Blenheim Design and Management.

SCHEDULE OF DESIGN ADJUSTMENTS TO CONSENT REF 18/00598/APP FORMING THE BASIS OF THIS RESTROSPECTIVE PLANNING APPLICATION.

Proposed Elevation

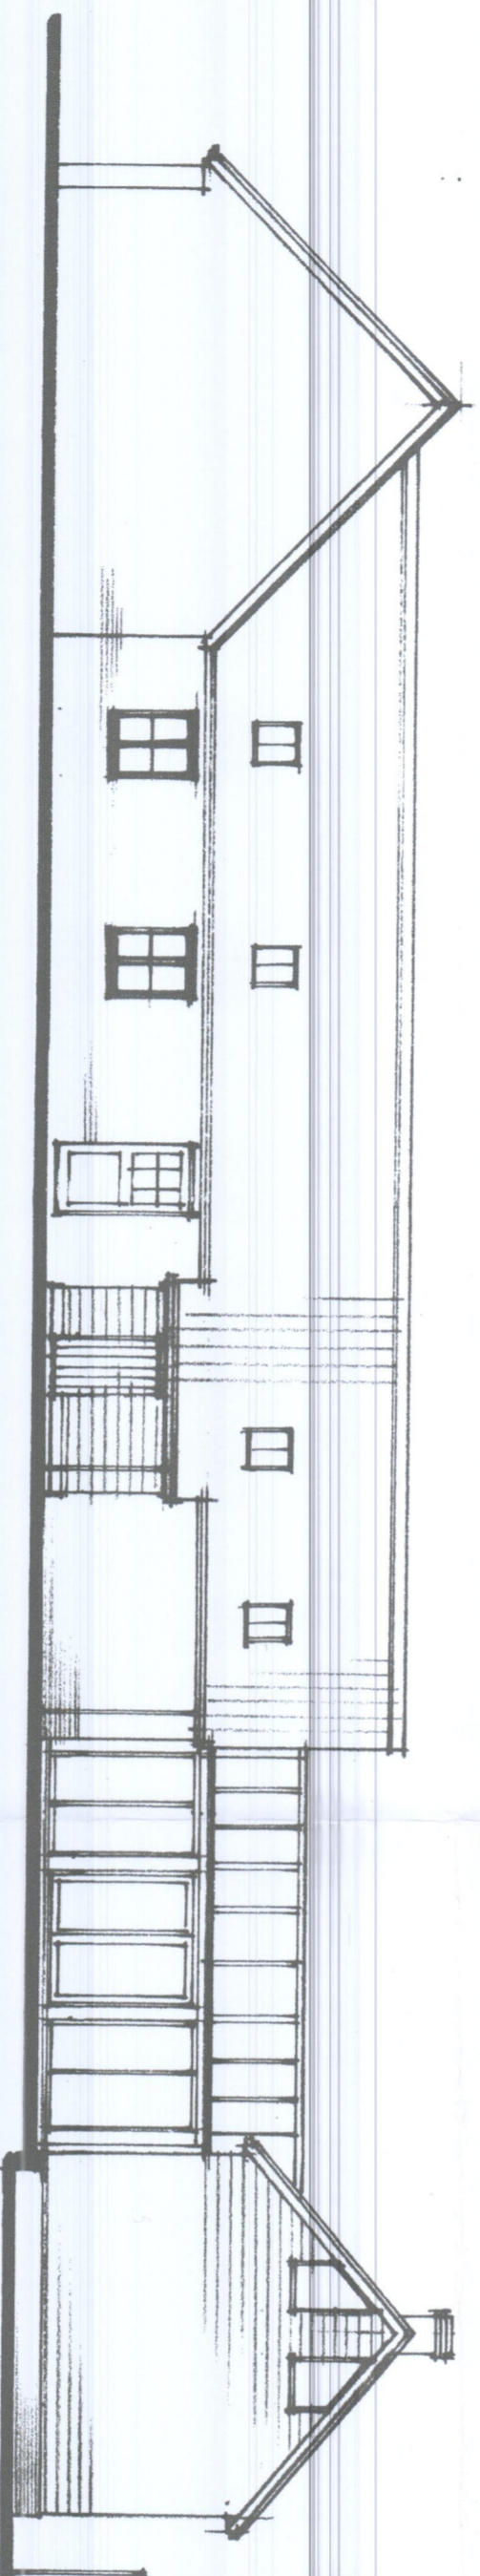
3. Addition of a chimney stack in lieu of steel flue.
4. High level gable windows reduced in size.

1. Additional window facing courtyard, NE Elevation.
2. Window design to SW Elevation altered following discussion/agreement with neighbours.
3. Boundary fence proposed in lieu of Brick wall – not constructed, windows obscured temporarily whilst options considered.

1. Minor adjustments to windows on NE Elevation

1. The facing brickwork to the SE Elevation was beyond economic repair and would have resulted in the wall losing its historic detail. To preserve this the wall was timber clad to match Barns 1, 2 and 5, retaining the original facing brick behind the cladding.
2. Windows added to NW Elevation and timber clad plant room added to provide space for plant serving round Source Heat Pump.
